**Rampion 2 Offshore Wind Farm (Project Reference: EN010117)**  
**Principal Areas of Disagreement Statement (PADS) – Version 1**  
**West Sussex County Council**  
**November 2023**

This report has been prepared by West Sussex County Council (WSCC). WSCC is a host authority for the Rampion 2 Offshore Wind Farm DCO, which was accepted on 20 September 2023 by the Planning Inspectorate for Examination. This document identifies the initial principal areas of disagreement that have been identified following review of the DCO documentation.

- Key**
- Development Consent Order Limits
 - Hedgerows unaffected by the proposed development**
 - Hedgerow
 - Hedgerows which may be removed within the Order Limits**
 - Hedgerow

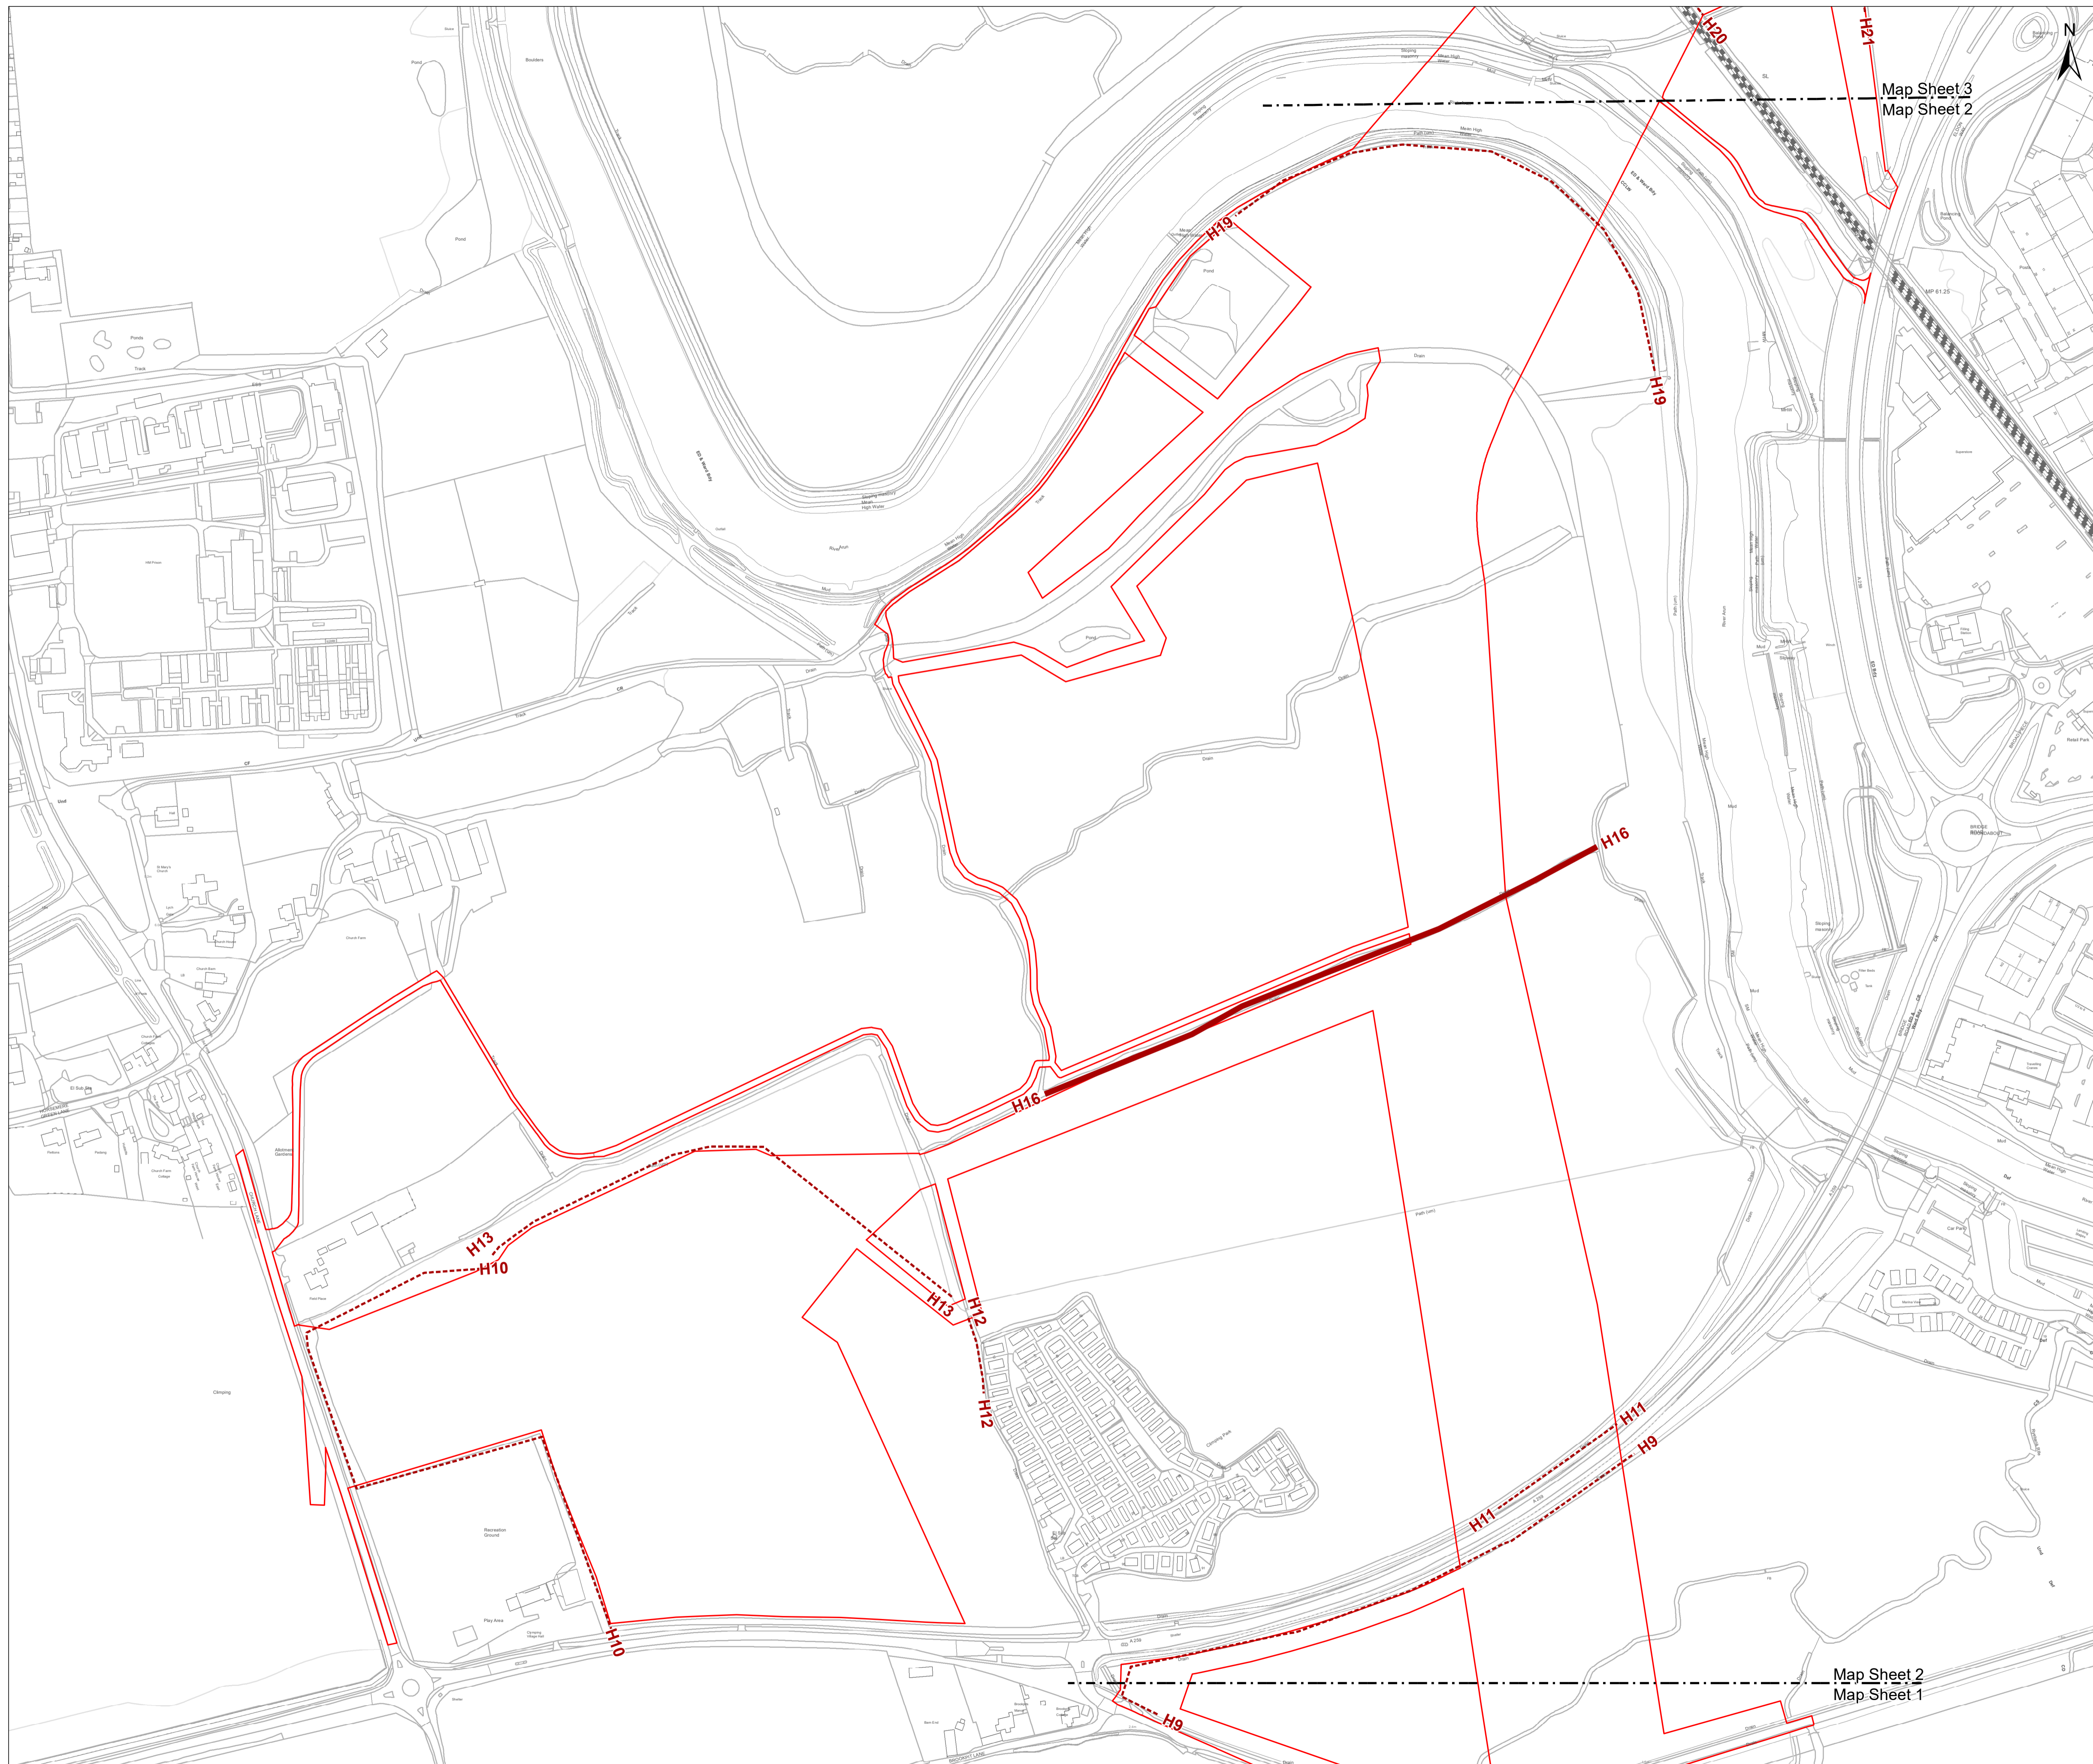
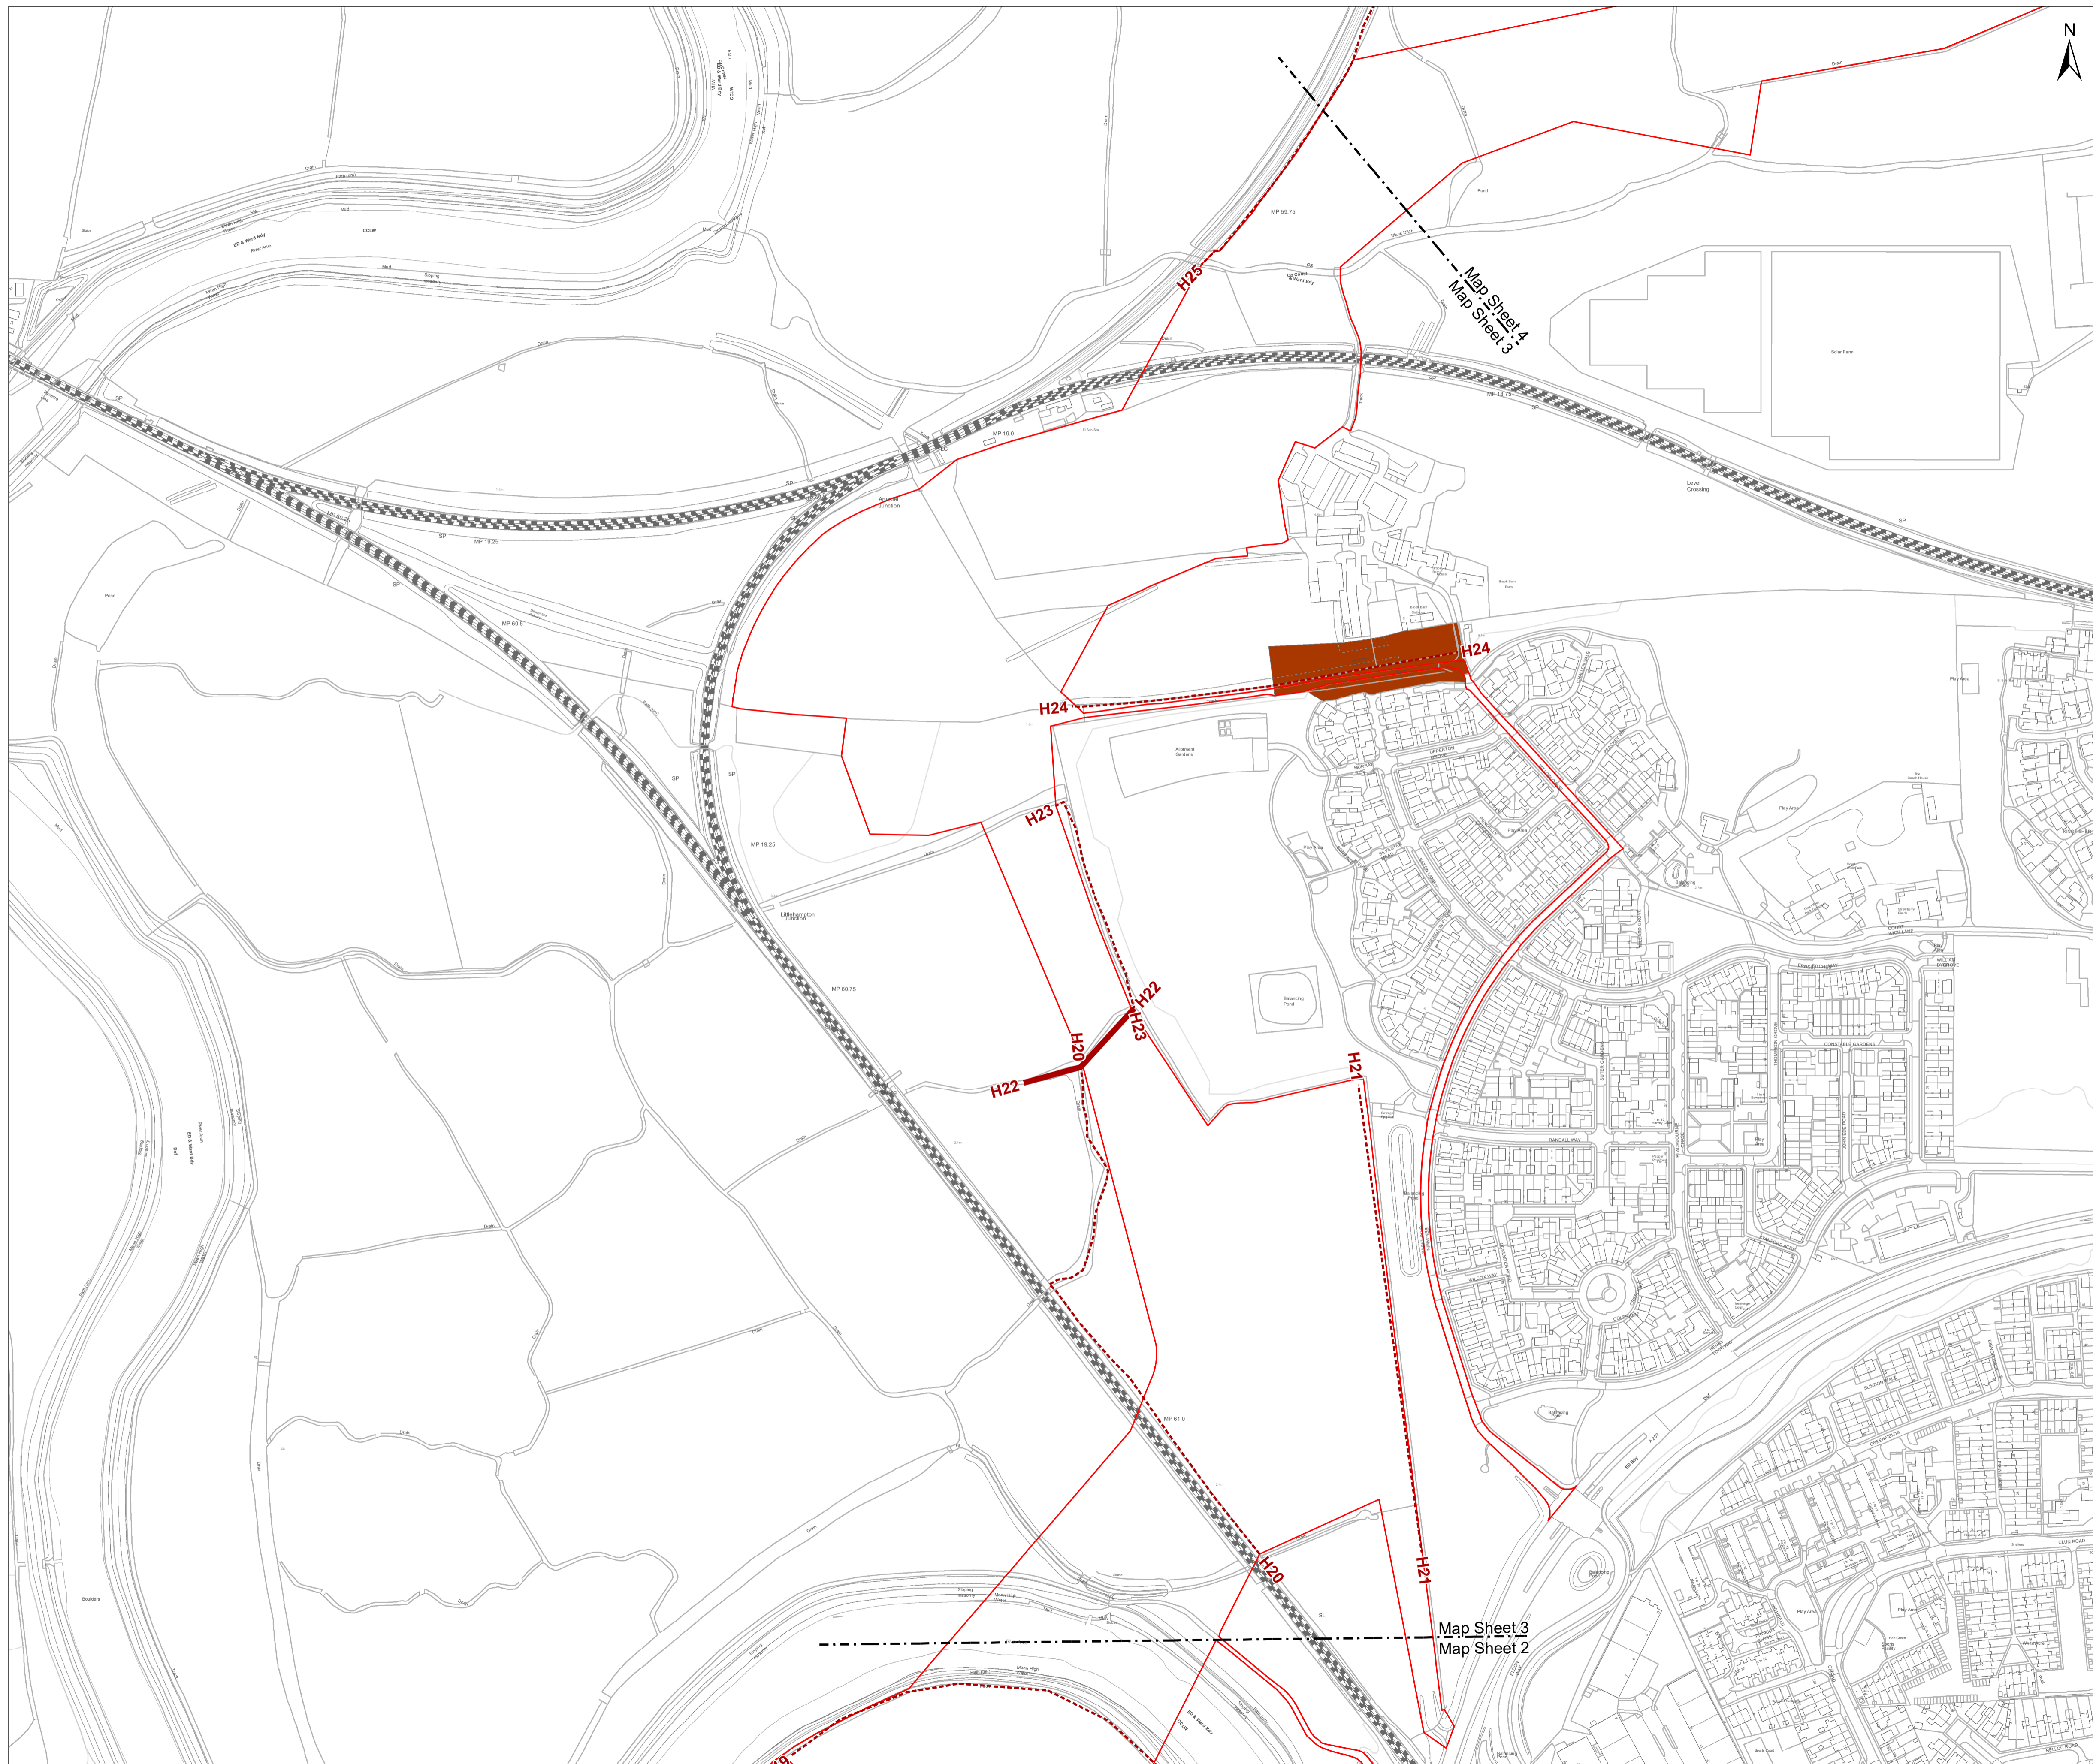
| 30.                          | Important hedgerows are not adequately identified across multiple documents and plans.   | Removal or damage caused to hedgerows including those determined as 'important'.  | The following must be consistent with hedgerow references and survey findings: Schedule 13; Tree Preservation Order and Hedgerow Plan; Hedgerow Survey Report; and Hedgerow Retention and Treeline Retention Plan.  | Uncertain |
